M54- M6 Toll Link Road

Planning Inspectorate Reference: TR010054:

**Summary of Natural England's written representations**

3 November 2020

Plot Date: 23 January 2020 15:05:58  
File Name: \\UK\h2p\psw001\1\ie\ENVIRONMENT\Practice Areas\GIS\Projects\M54\M6 Link\Workspace\Stage 3 Figures\Landscape and Environment-Air Quality\HE514465-ACM-EGN-M54\_SW\_PR\_Z-DRLA-0002 - Figure 5.2 - Air Quality Baseline.mxd

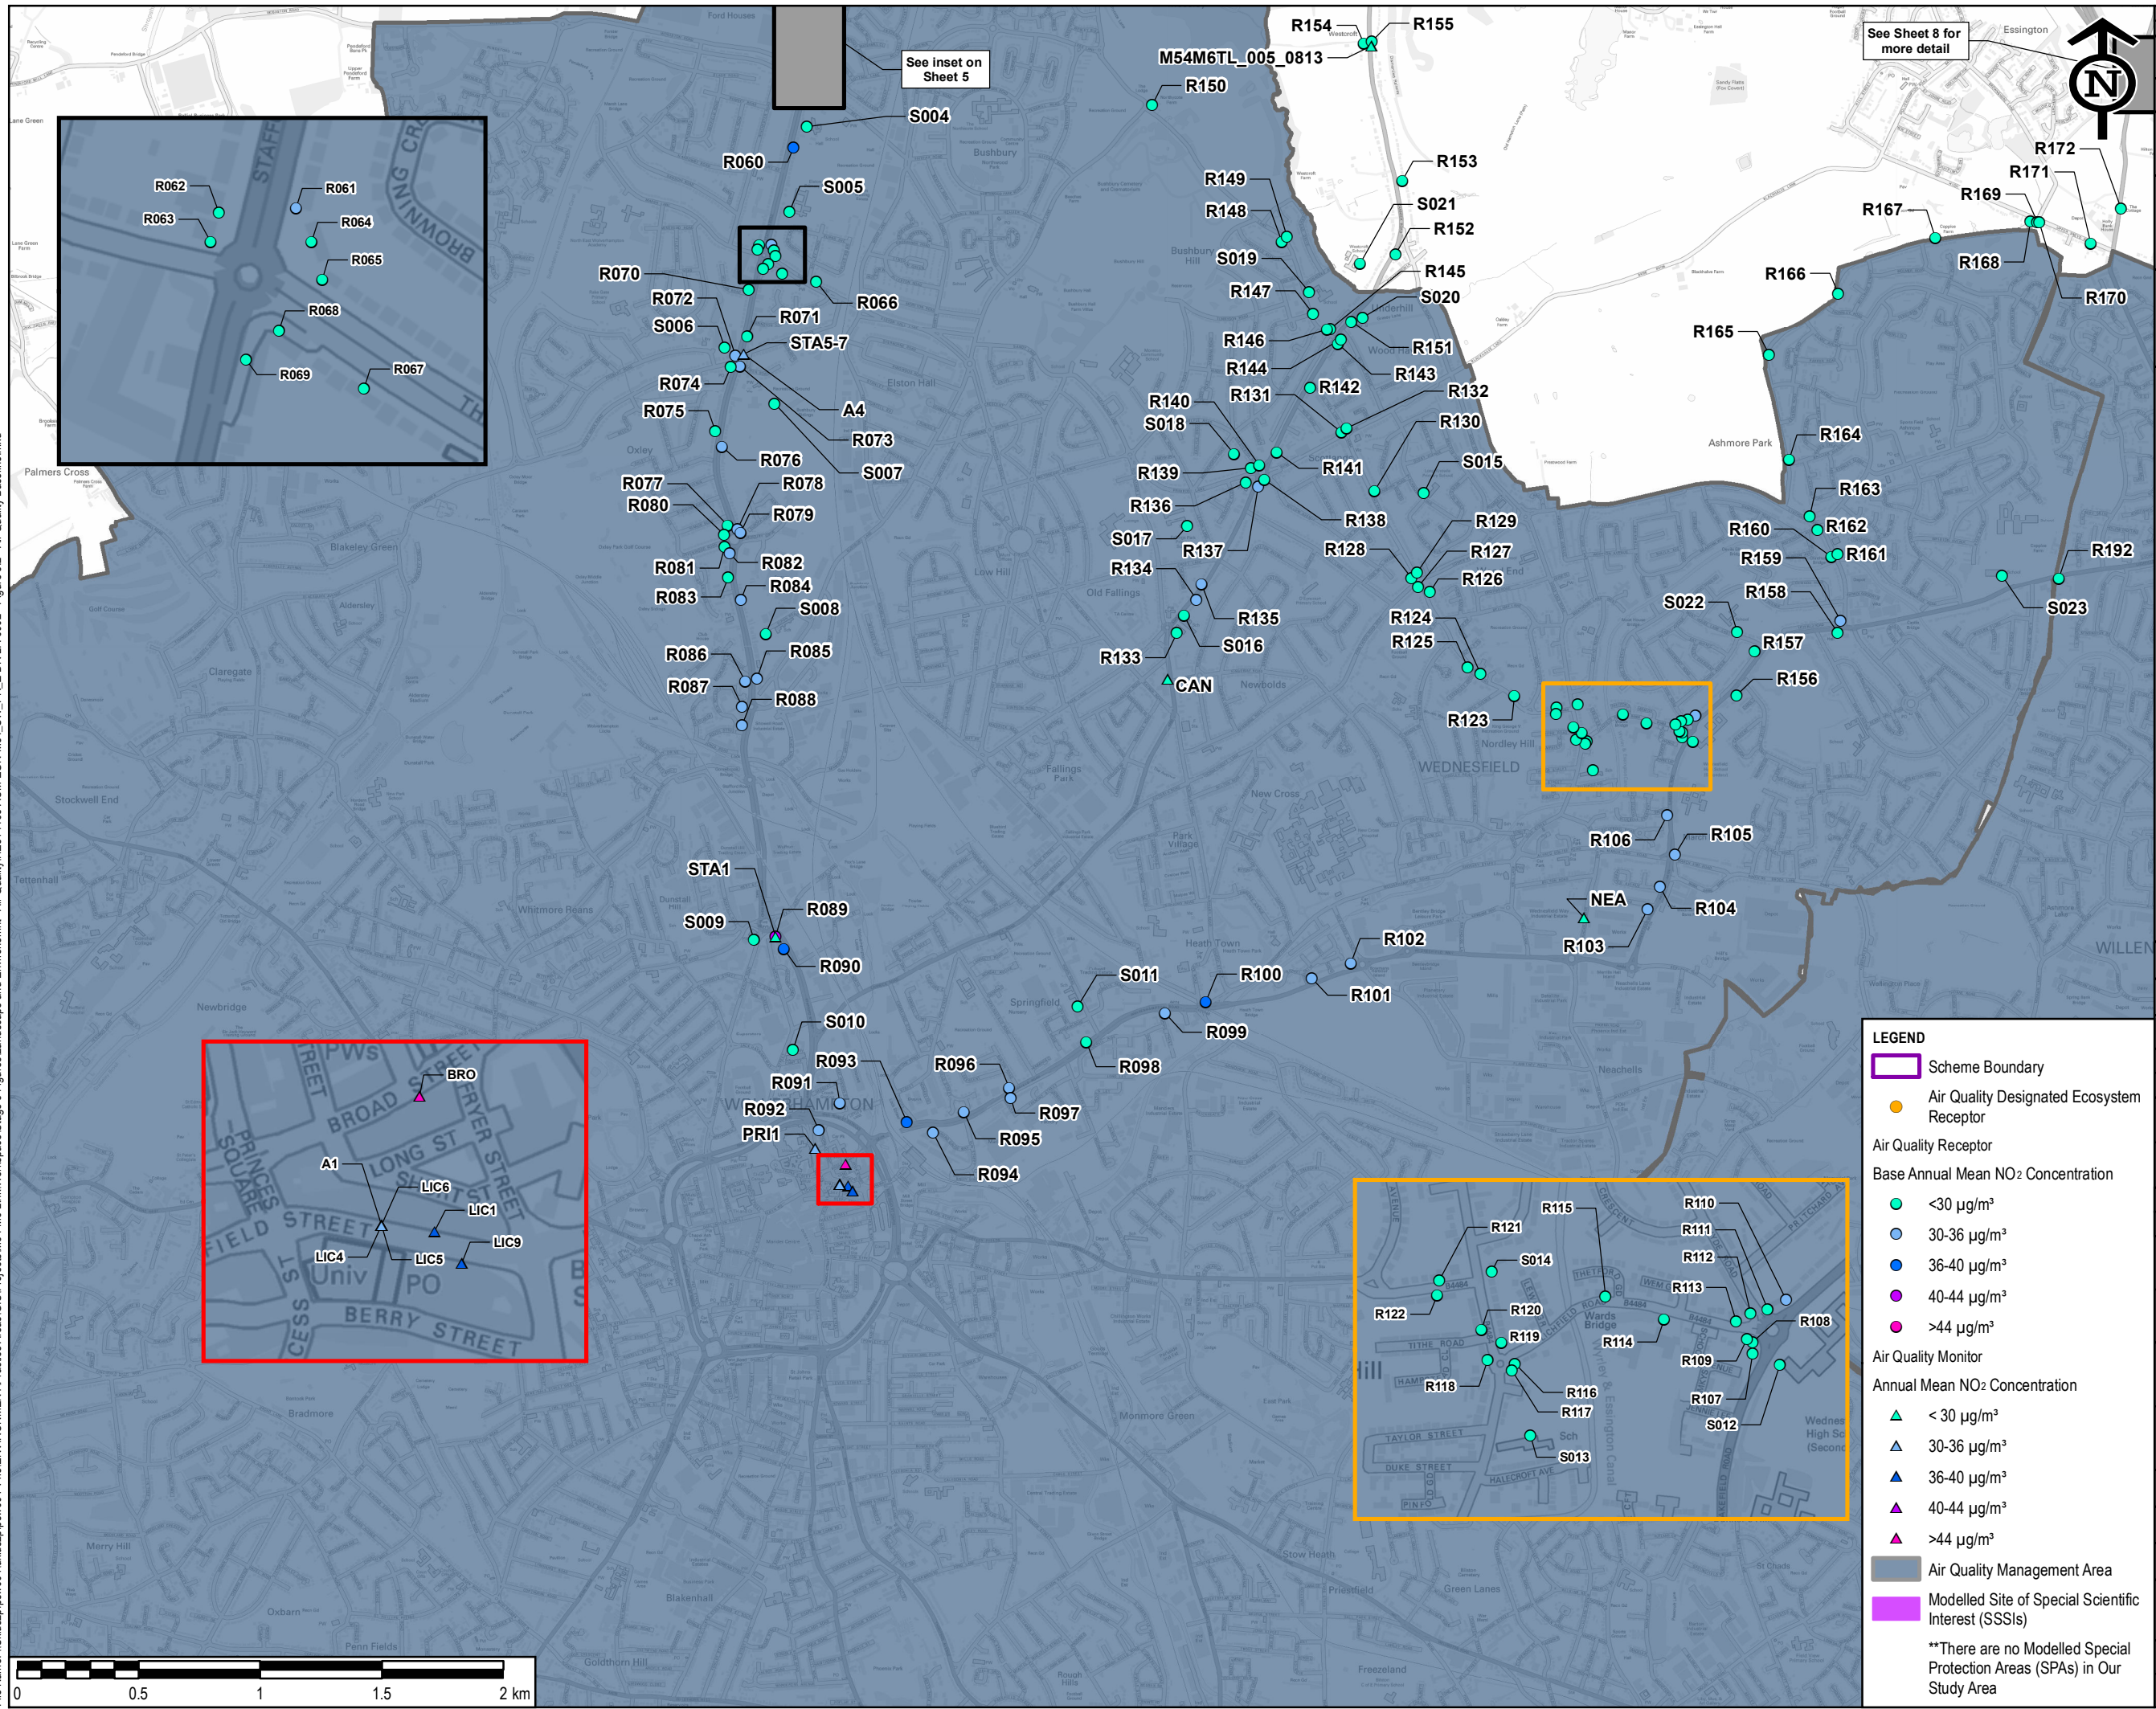
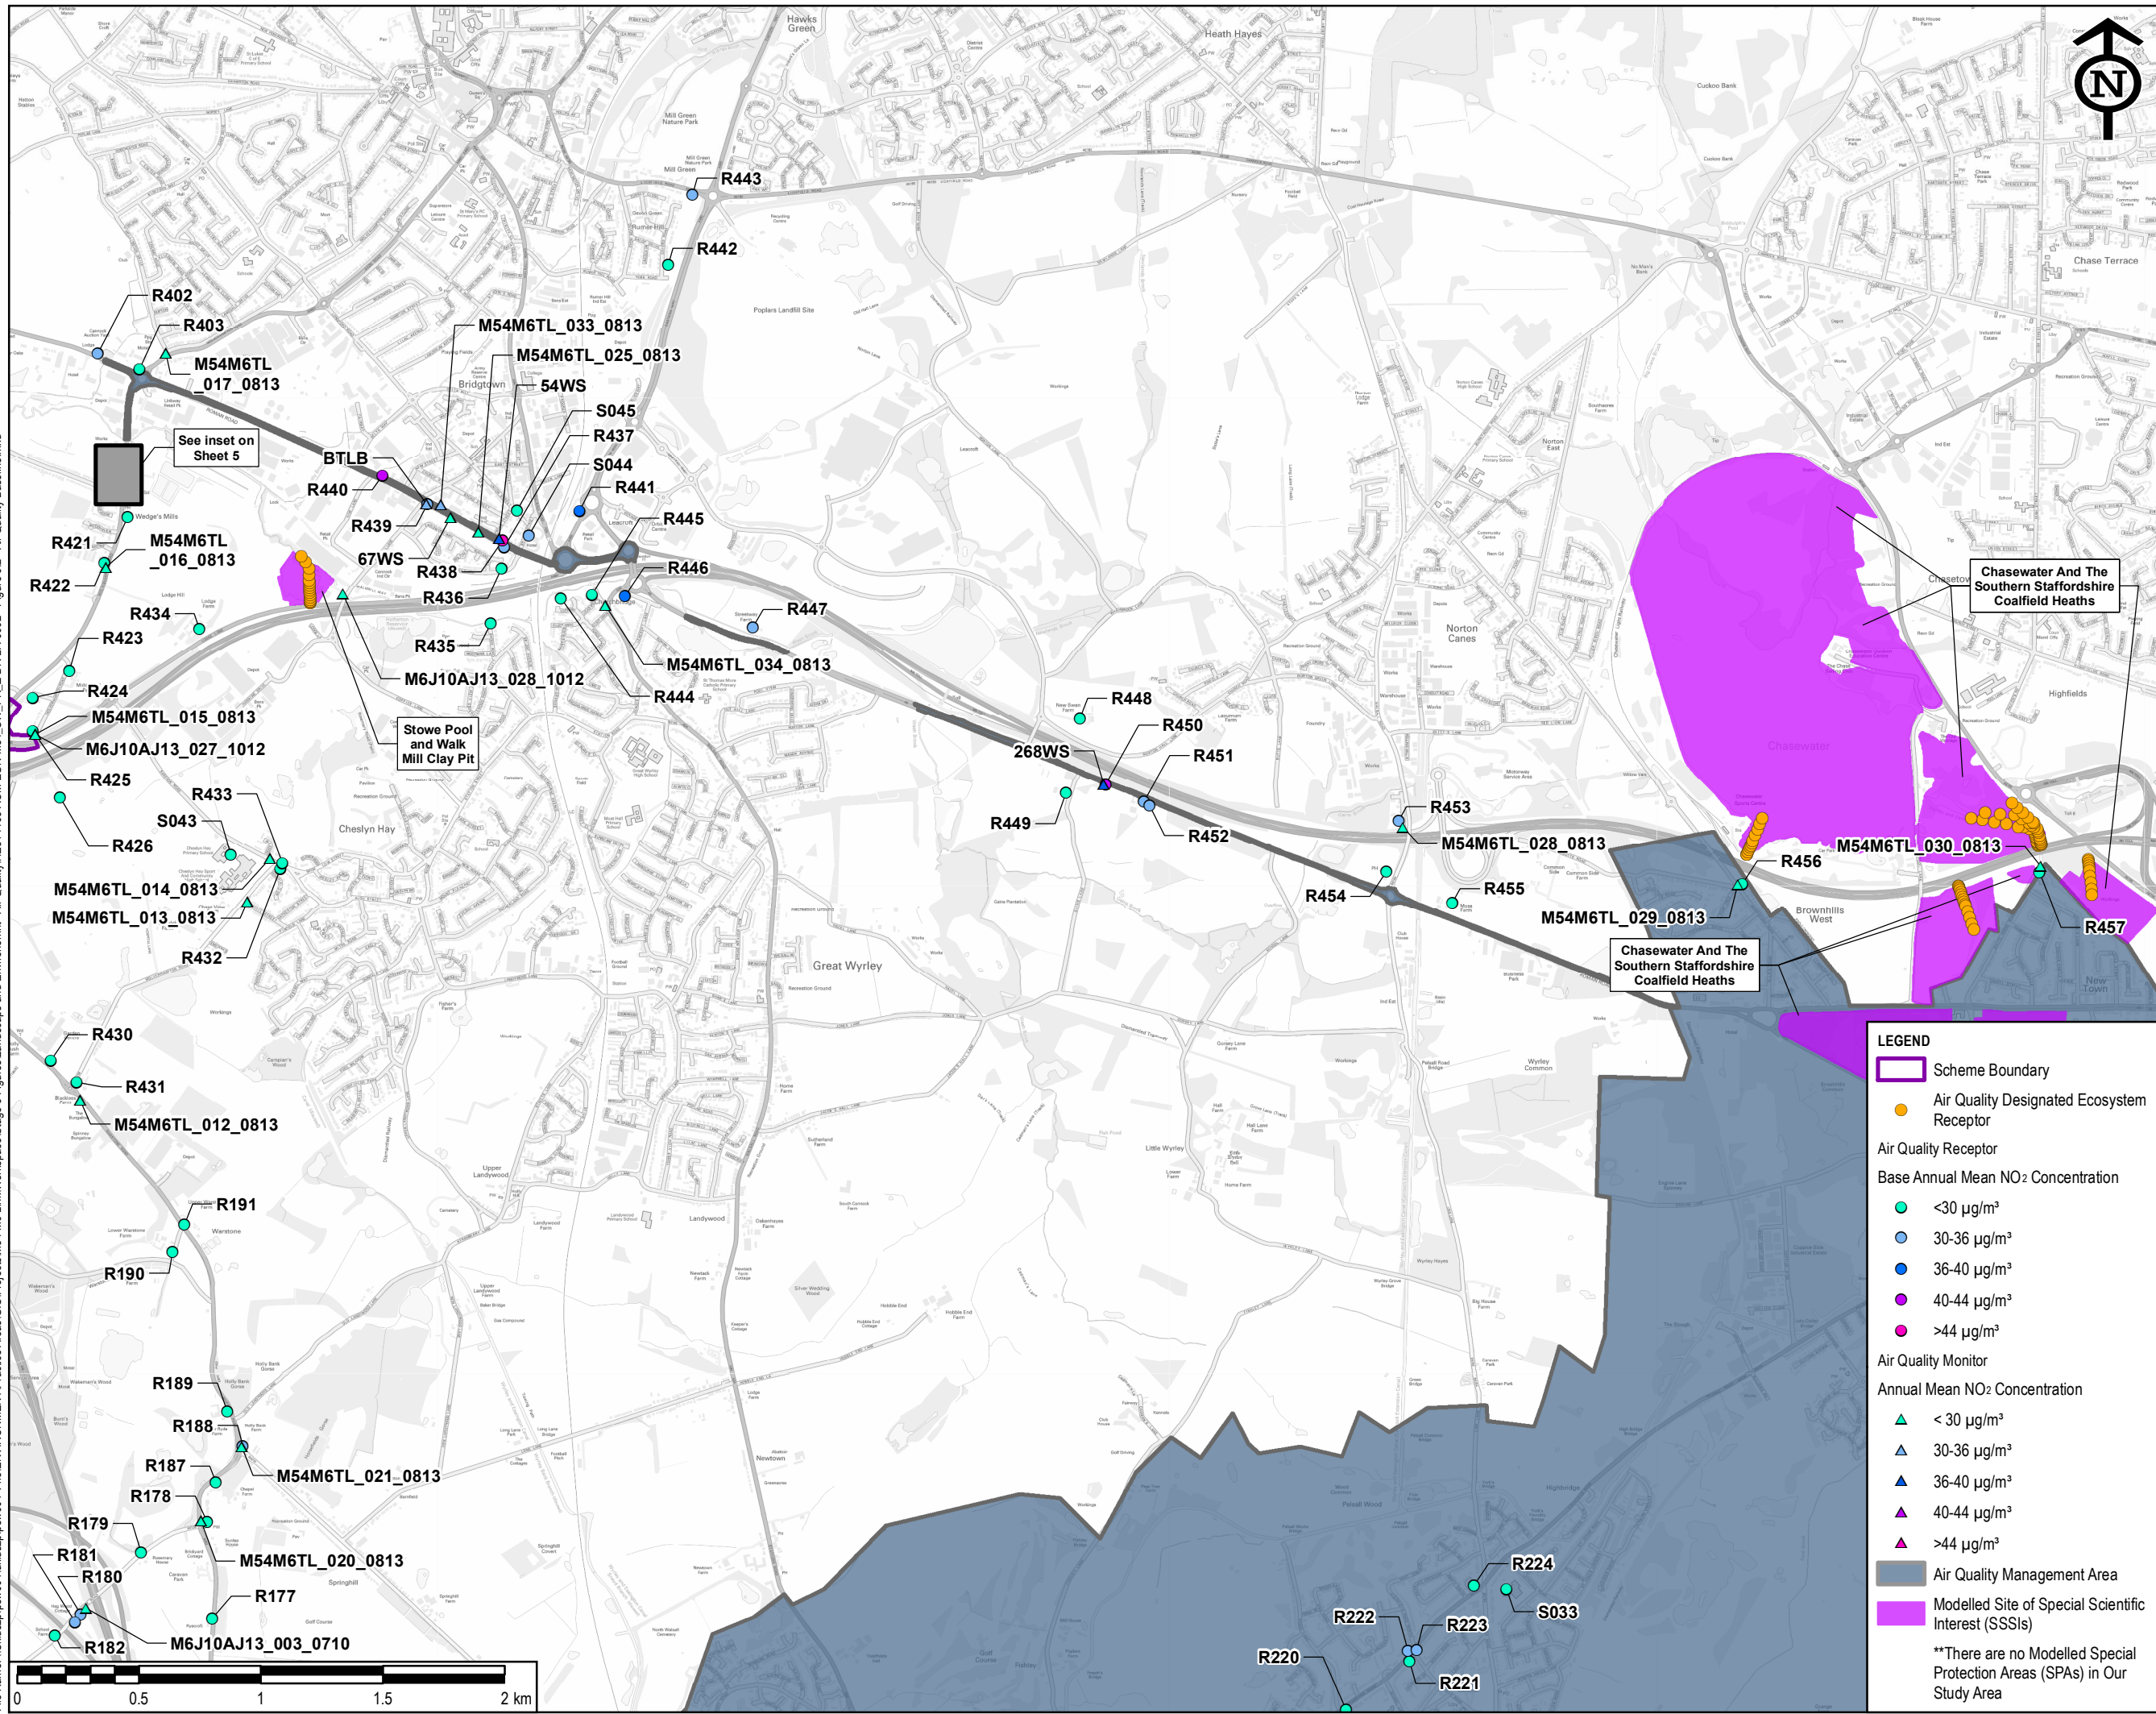
- Confirmation that example sites have been screened out.
      - Indirect impacts require consideration. Cannock Extension Canal SAC is hydrologically linked to Chasewater and Southern Staffordshire Coalfield Heath SSSI, which will be affected by nitrogen deposition.

- 3.2. Nationally designated sites
    - Chasewater and the southern Staffordshire Coalfield Heaths SSSI
    - Stowe Pool and Walkmill Claypit SSSI
      - The scheme would result in increases in NOx and nitrogen deposition at these sites further discussions are required over the assessment and conclusions with regards to potential impacts of these increases (alone and cumulatively) and mitigation.

- Where there is unavoidable loss of ancient woodland the Applicant and Natural England have agreed a ratio of replacement planting and improvement works to Oxden Leasow Wood (also known as Whitgreaves Wood). The detail of the compensation measures requires further discussion.
- Increases in nitrogen deposition on Oxden Leasow Wood and woodland at Brookfield Farm require further discussion on potential impacts on impacts alone and cumulatively.
